June 20, 2008

Mackenzie Moynihan  
Community Development Services

Thank you for the opportunity to comment on B & J Preliminary Plat, LP-08-00021. I recommend that this plat utilize a Group B water system to serve the 7 lots. A well site inspection must be performed to approve the site where the well is. The group B workbook and all associated paperwork must be turned in and the system design approved prior to final plat approval.

B & J PLAT
PART OF SECTION 7, T. 17 N., R. 18 E., W.M.
KITTITAS COUNTY, WASHINGTON
- PRELIMINARY PLAT -

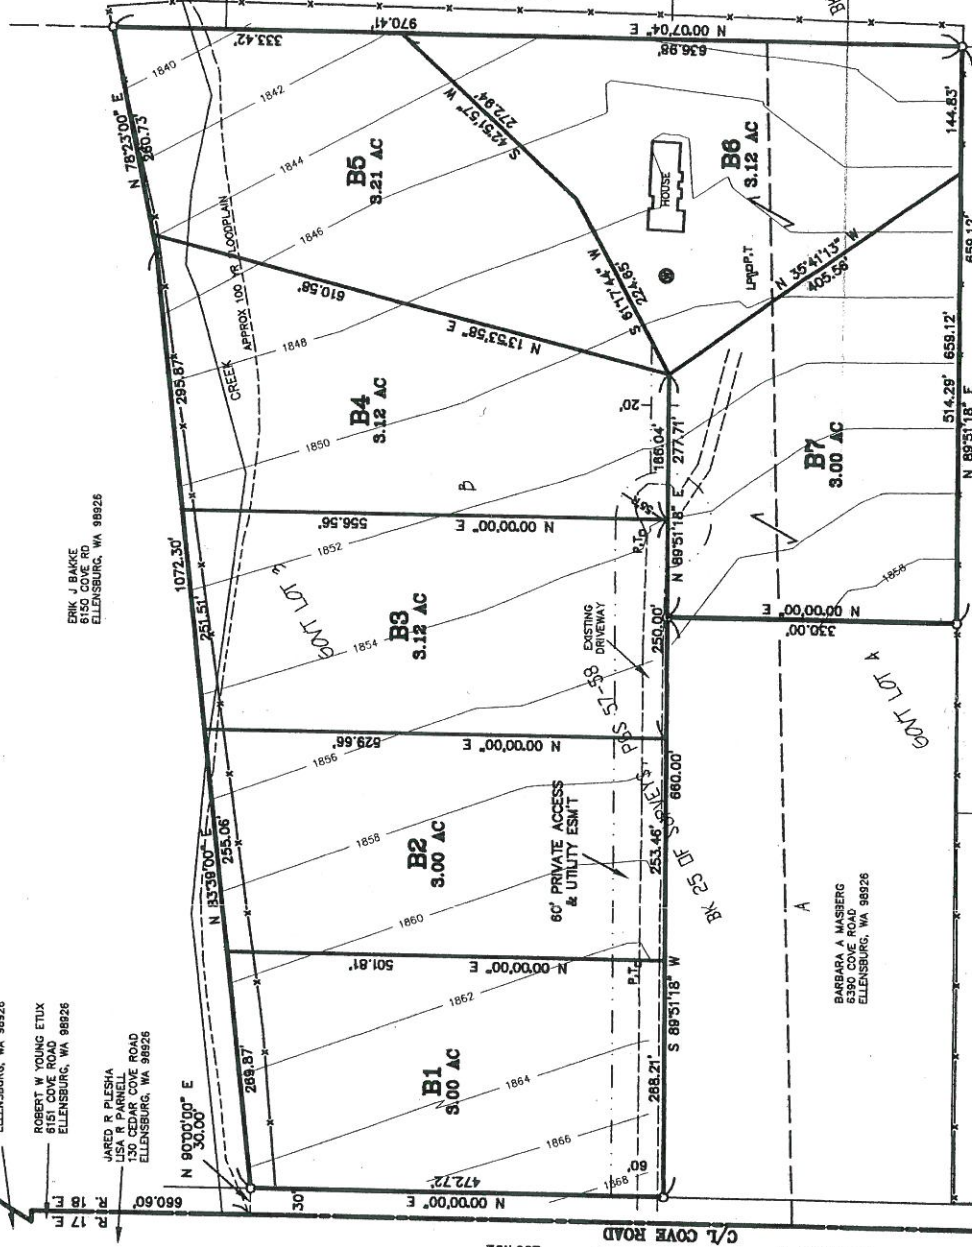
Soil logs are required for each lot where installation of a septic system is intended
